# North West Growth Centre water related services for first release precincts

Modification Assessment Report

**RESPONSE TO SUBMISSIONS**

July 2012

Figure 1 Location of additional drinking water and wastewater infrastructure - 'the Modification Proposal'

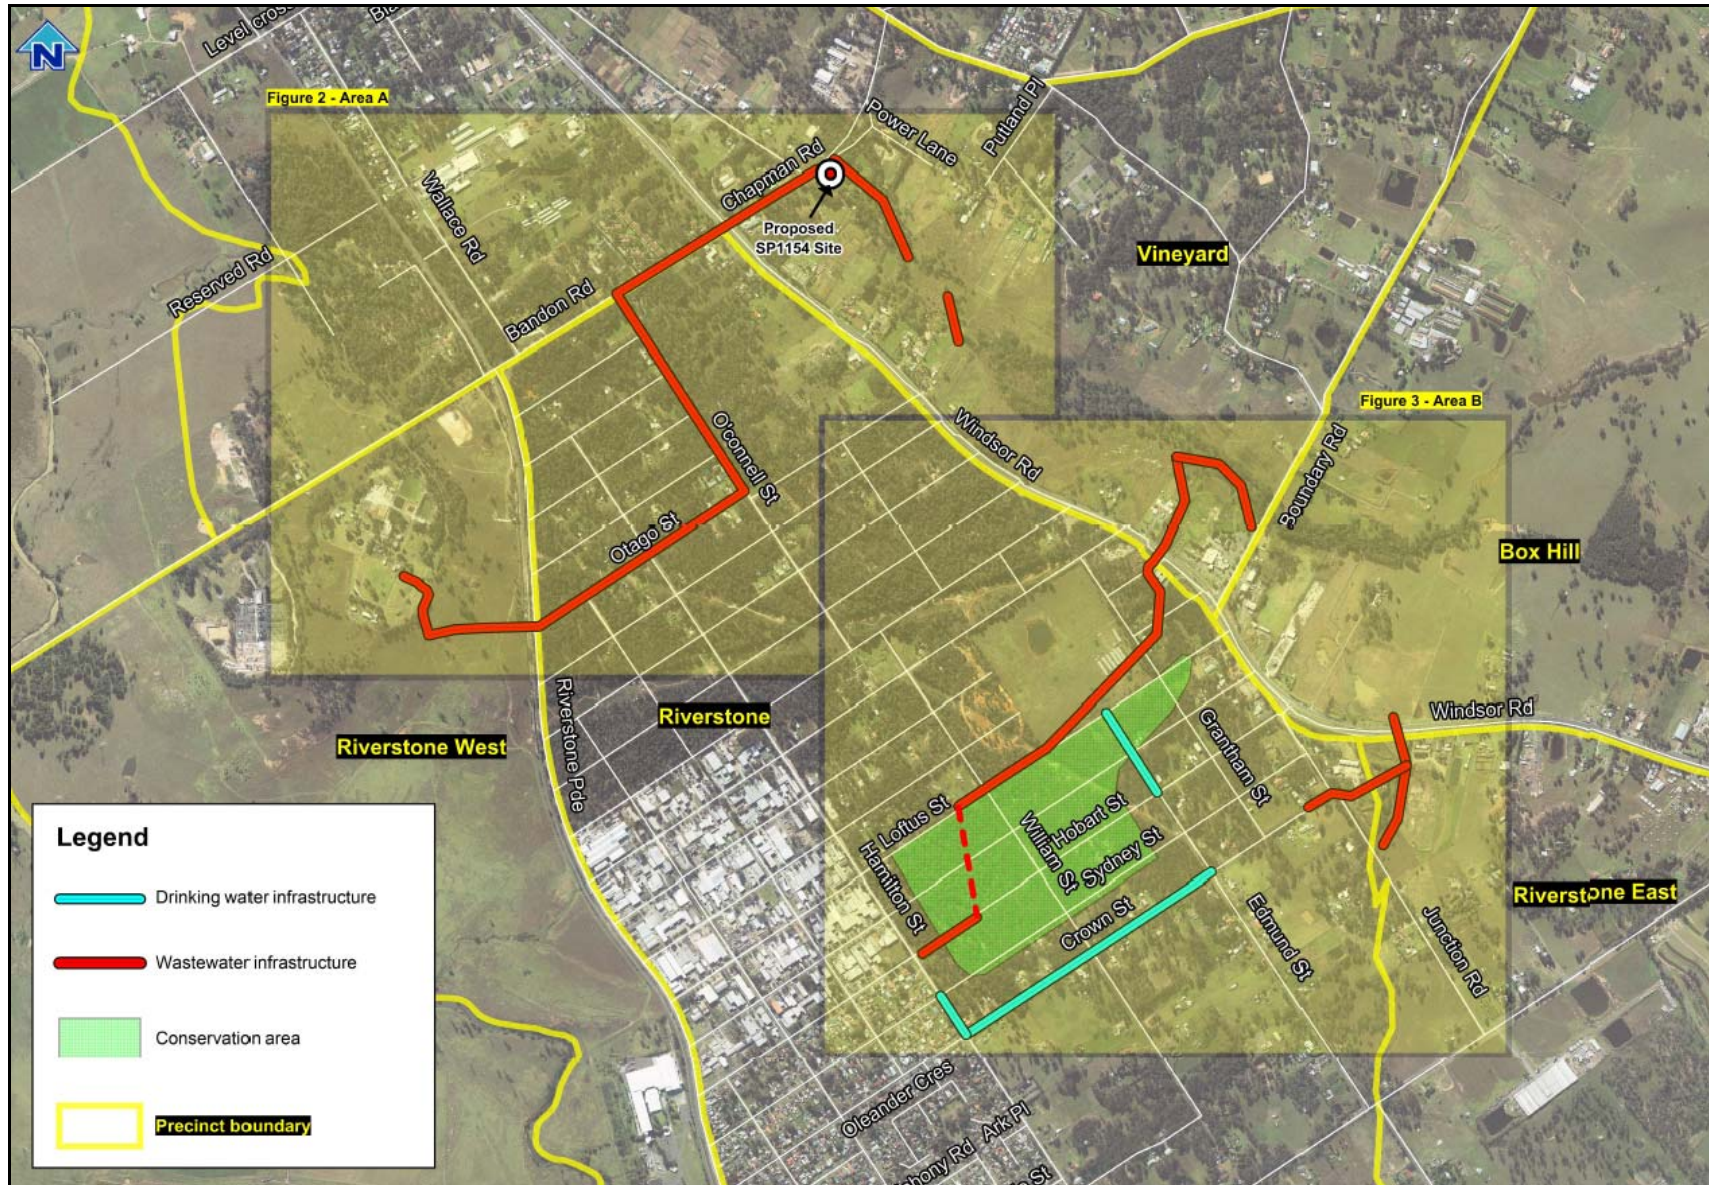
3. Clarify whether all infrastructure shown on Figure 1 has been assessed, if not recommend additional survey as there is non-certified ENV and given the number of records of threatened species and endangered ecological communities in the study area.

Figure 1 in the Modification Assessment Report shows all infrastructure associated with modified scope of works. All pipelines have been assessed. Some of these pipelines were assessed in the

original EA, and therefore have not been assessed again in the Modification Assessment report. This included the section of Rising Main 3 along Bandon Rd and Chapman Rd as it formed part of one of the rising main alignment options from the original SP1154 site location. This section of pipeline does traverse certified and non-certified land, however no vegetation impacts were recorded in the 2007 flora and fauna assessment as it is to be built in the road corridor.

Crown St and Hamilton St drinking water pipelines were assessed in the MAR (Appendix D - Ecological Impact Assessment (see Figure D.3 and Table E.6). They were not shown on Figures 4 and 5 of the MAR, taken from the Ecological Impact Assessment report as these were additional lines assessed. However they do form part of this Modification proposal as described in Table 1 of the MAR. Sydney Water has updated Table 4 from the MAR, see Table 3-1 below, to include these drinking water pipelines as a line item. The Crown St and Hamilton St pipelines do not result in clearing of any non-certified ENV, and therefore do not impact the amount of ENV to be offset.

Figure 3 The Modification Proposal – Area B

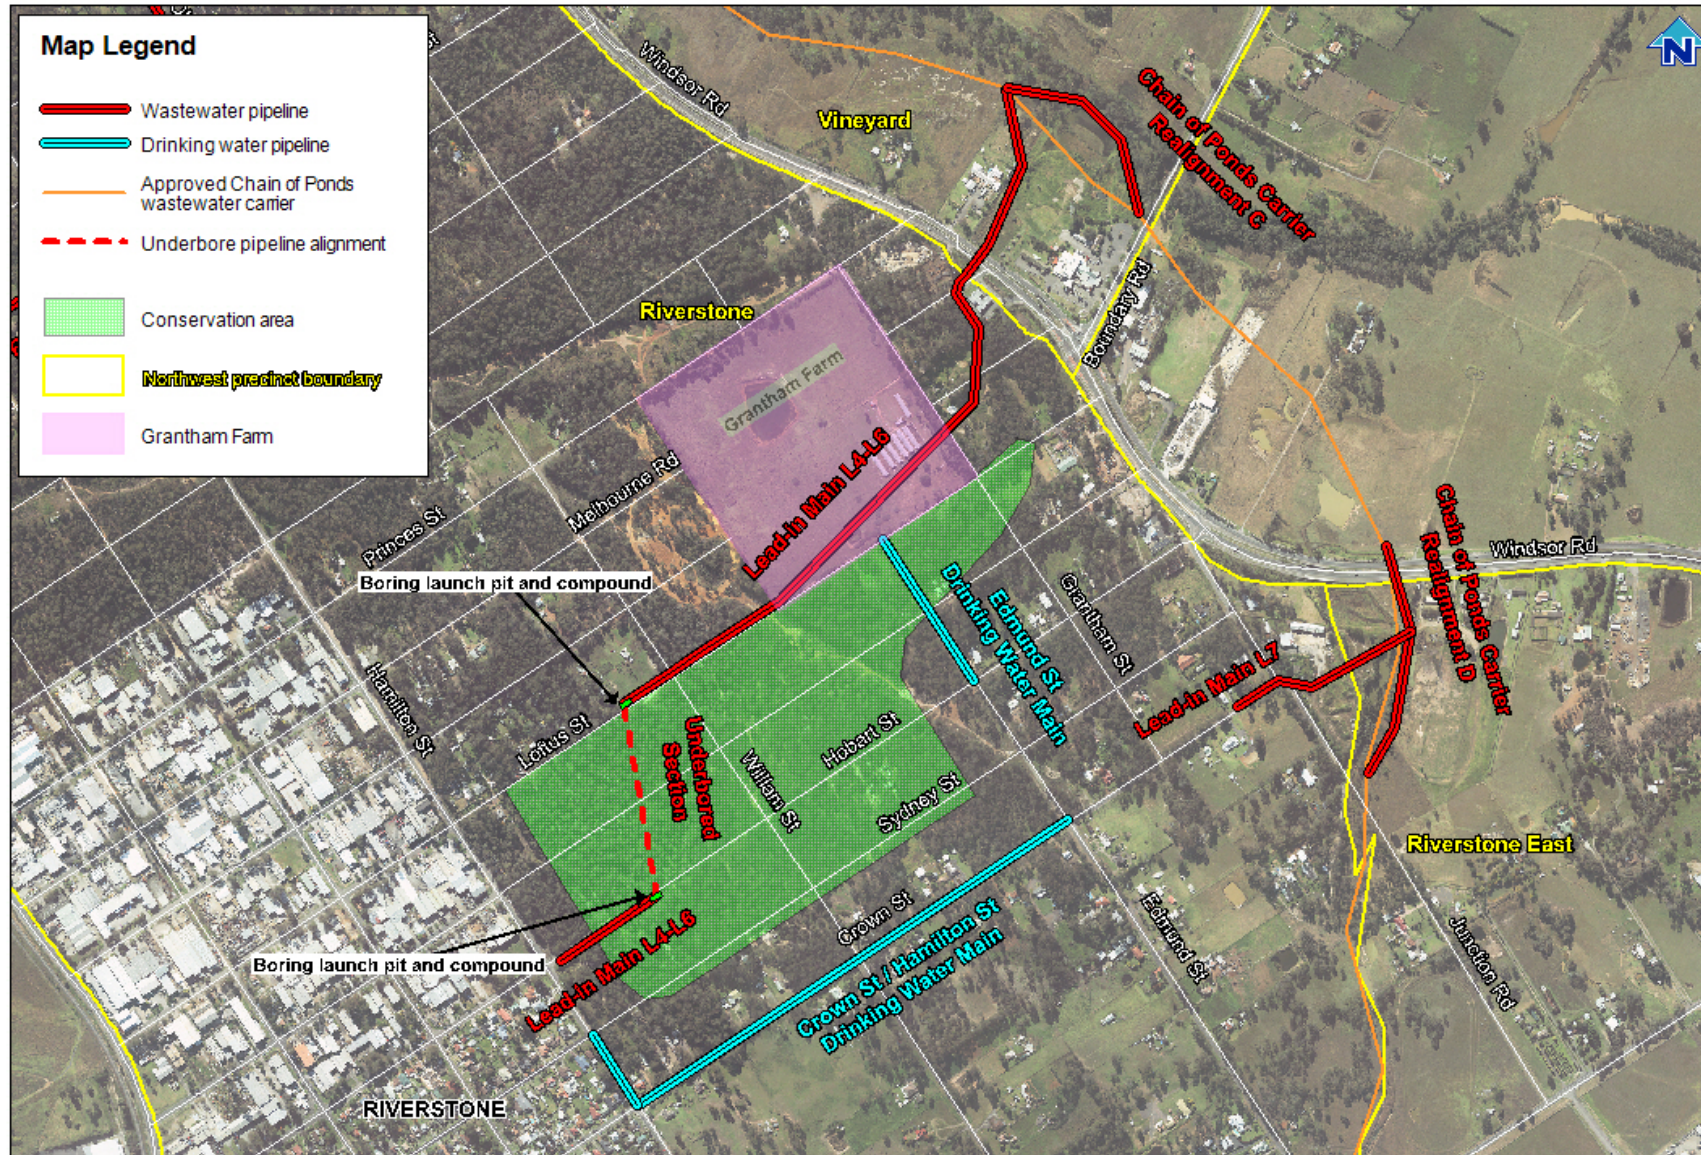
13. Clarify which locations for SP1154 were considered in the Aboriginal Heritage Impact Assessment (AHIA) Report, and confirm whether the specific recommendations for SP1154 site in the AHIA Report adopted for SP1154.

Four adjacent site locations on Chapman Road were considered in the AHIA report. Figure 3 shows these sites. Option A is the site closest to Windsor Rd and Option D is closest to the creek. Sydney Water balanced a number of factors when choosing the preferred location for SP1154 at Chapman Rd. This included proximity to the child care centre, residences, topography and location of creek, proximity to proposed sewerage carrier, location of ENV vegetation and heritage considerations.

Although the Aboriginal groups put in a preference to have the site further away from the creek to reduce likelihood of impacting any unidentified potential heritage items, the site inspection with the groups did not identify the site as having any heritage significance. The chosen site is Option D, which is closest to the creek, but located outside the riparian corridor, at least 75 metres from the creek.

Figure 7 Extent of indirect impacts through fragmentation of ENV for the Modification Proposal

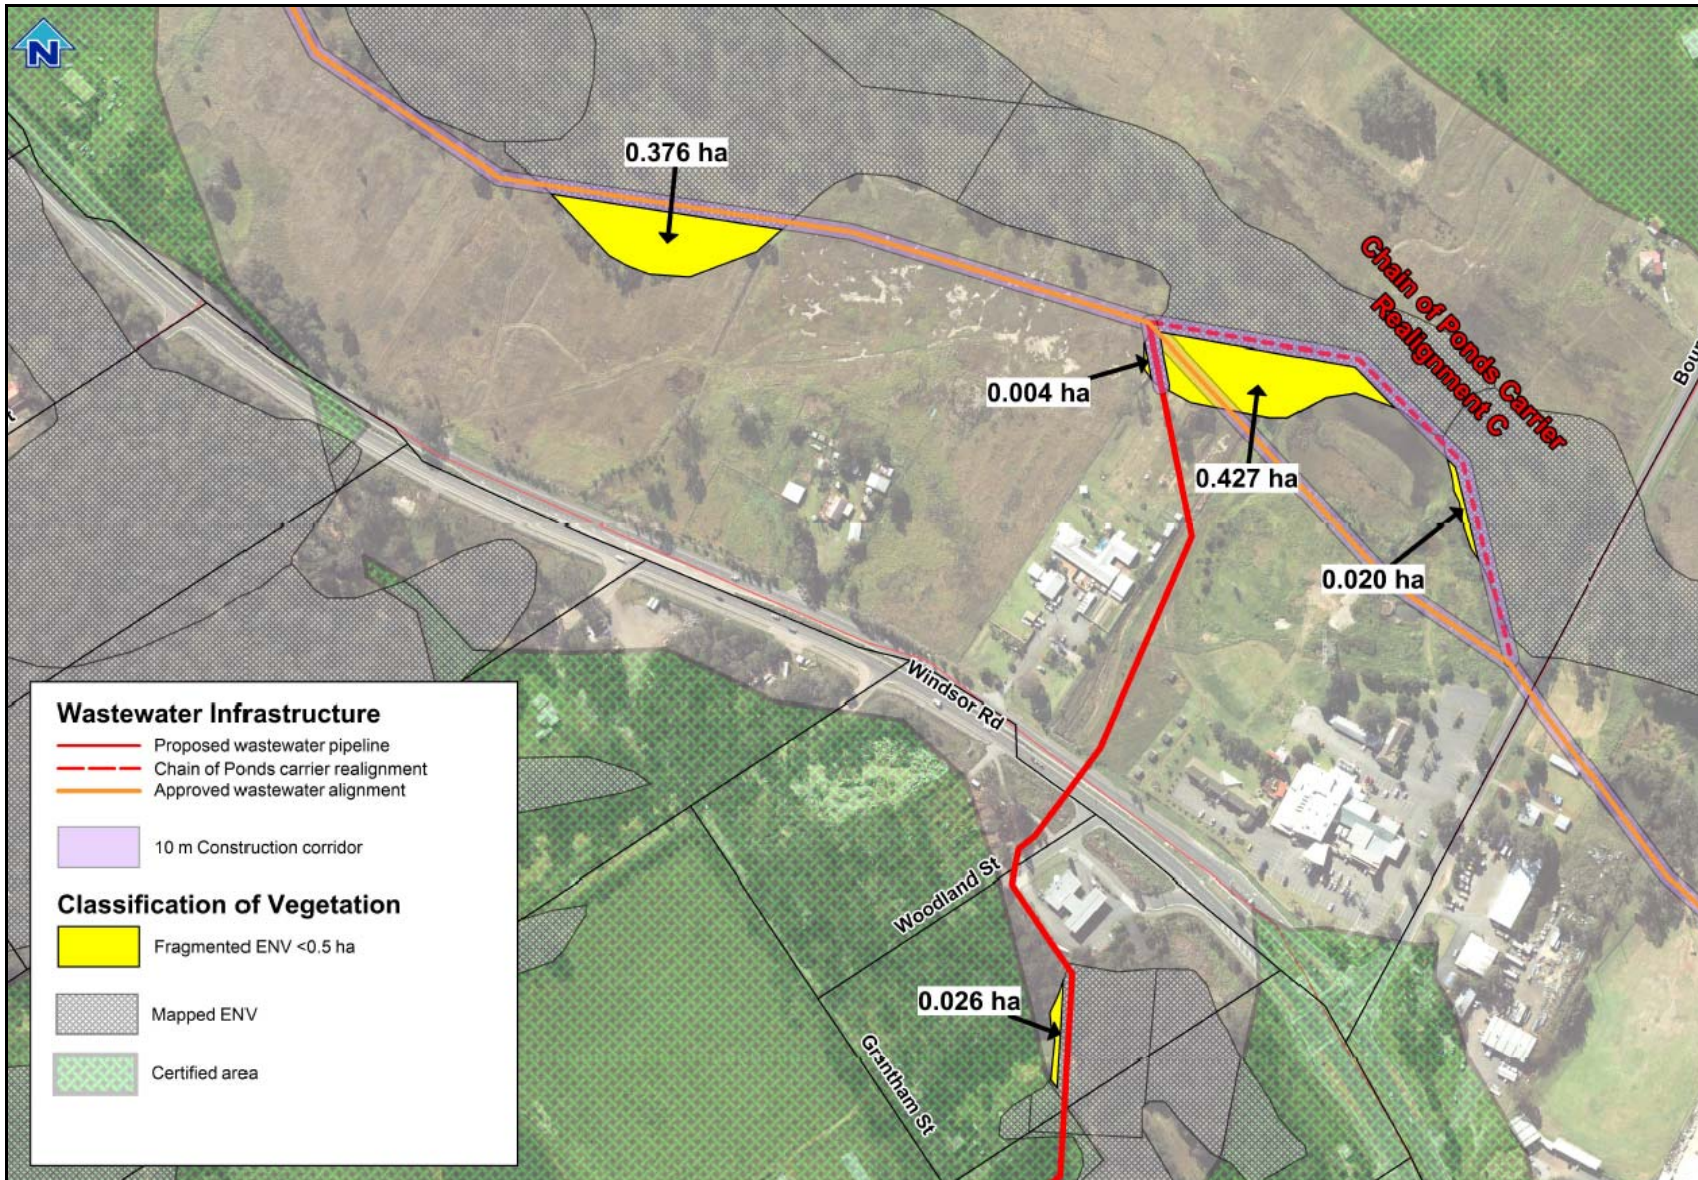
8. Request that areas of ENV fragmented as a result of the Modification proposal should be included in the calculation of vegetation required to be offset.

As outlined in section 3.2.3 of the MAR, there are a few sections on the Chain of Ponds Carrier where vegetation removal would result in patches of ENV in non-certified areas no longer meeting the minimum size criteria. The total area of these patches is 0.86 ha.

Sydney Water believes the Modification Proposal's offset strategy within the NWGC is consistent with the Biodiversity Certification Order (BCO). The BCO prescribes the agreed offset approach for projects within the Growth Centres, and by Sydney Water's interpretation does not specify offset requirements for indirect impacts. Sydney Water does not consider it appropriate to provide biodiversity offsets for indirect impacts in addition to those required by the BCO.

Sydney Water considers revegetating areas of vegetation removal is an appropriate measure to mitigate the Modification Proposal's indirect impacts of fragmentation and loss of connectivity. Revegetation will ensure that loss of connectivity and fragmentation is a temporary impact, rather than long-term.
